Your Ref: P/20/18/DOC

Town & Country Planning Act 1990 (as amended)
Town and Country Planning (Development Management Procedure) (England) Order 2015
Approval of details reserved by conditions imposed under P/107/16/PL relating to conditions 3-
surface water drainage, 4-schedule of materials & finishes, 5-landscape scheme, 6-screen
wall/fence details, 8-site set up during construction, 10-storage of waste & recycling details , 11-
placement of 2 No. nesting opportunities for birds & 14-external lighting details.
7 Webb Close Pagham,,

Notification regarding the above application:

17017-104⁰

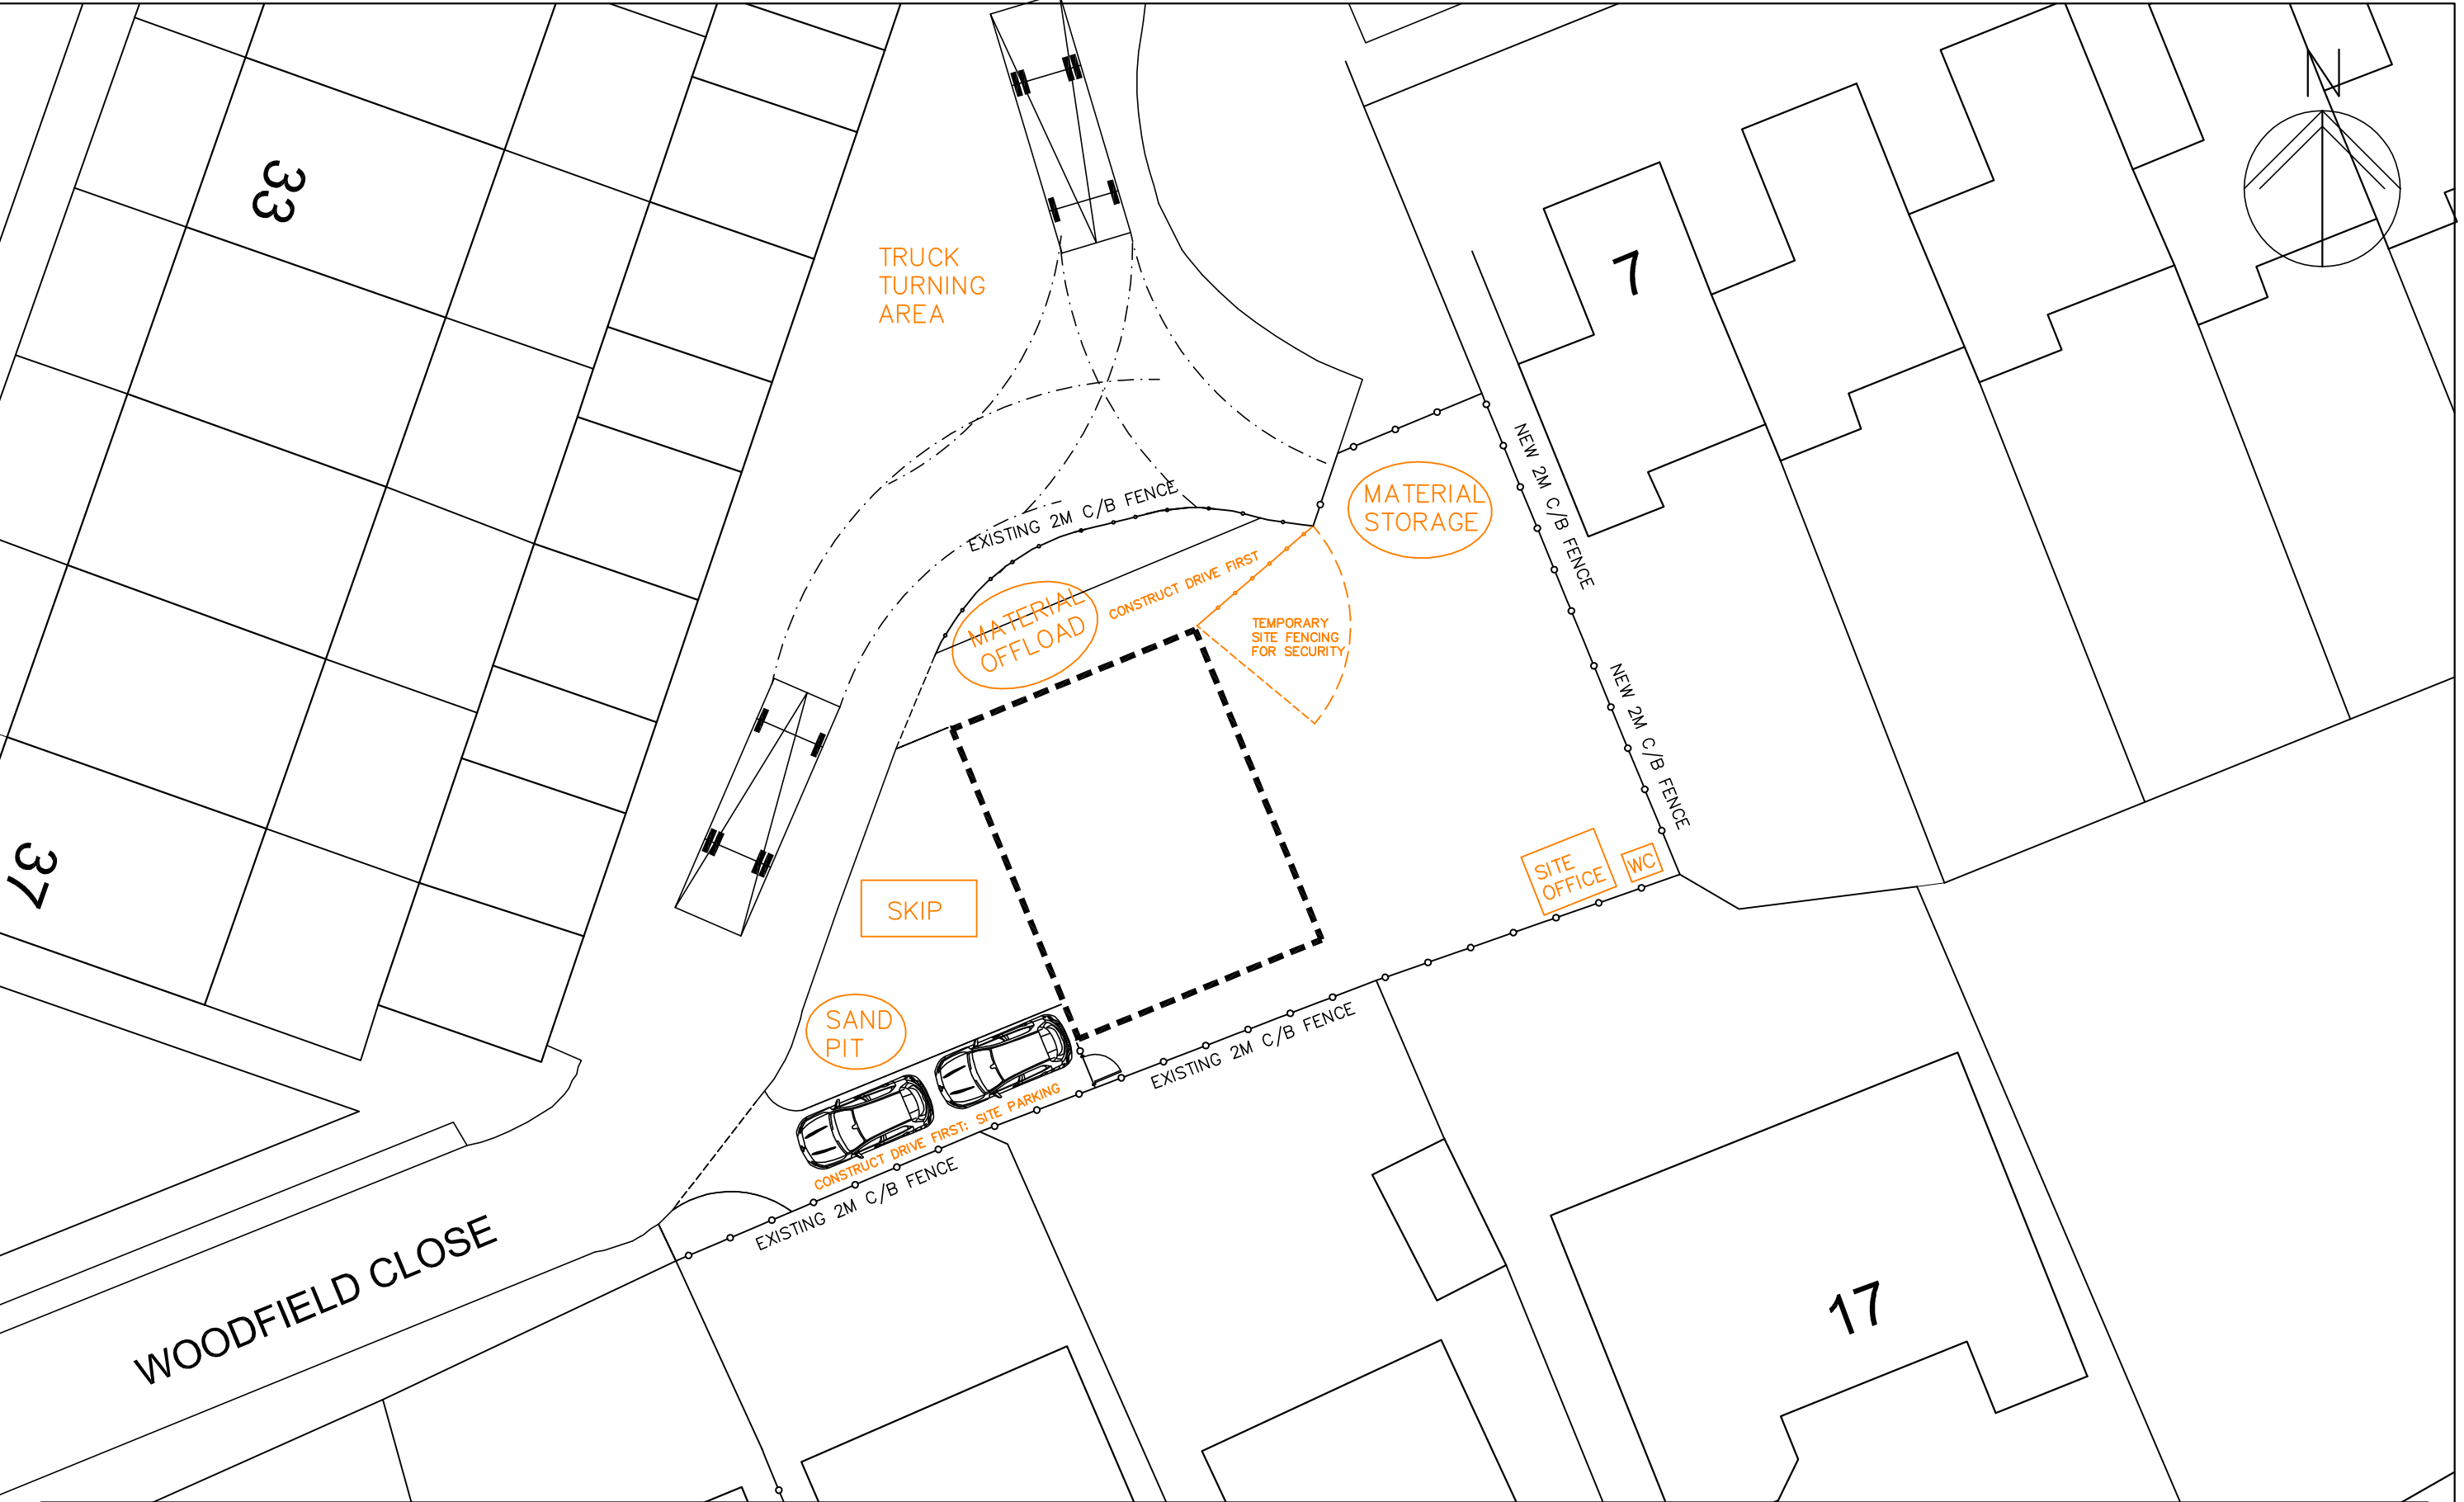
Arun District Council have decided to **APPROVE details reserved by this condition**
The proposed "Construction Layout" (Drawing 17017-104) has been agreed by West Sussex Highways and is considered to be acceptable. The condition is therefore fully discharged insofar as the submission of details relates and on the understanding that the site will be set up and managed during construction in accordance with the approved details. Please also ensure that local residents are informed of the time and size of anticipated large vehicle movements.
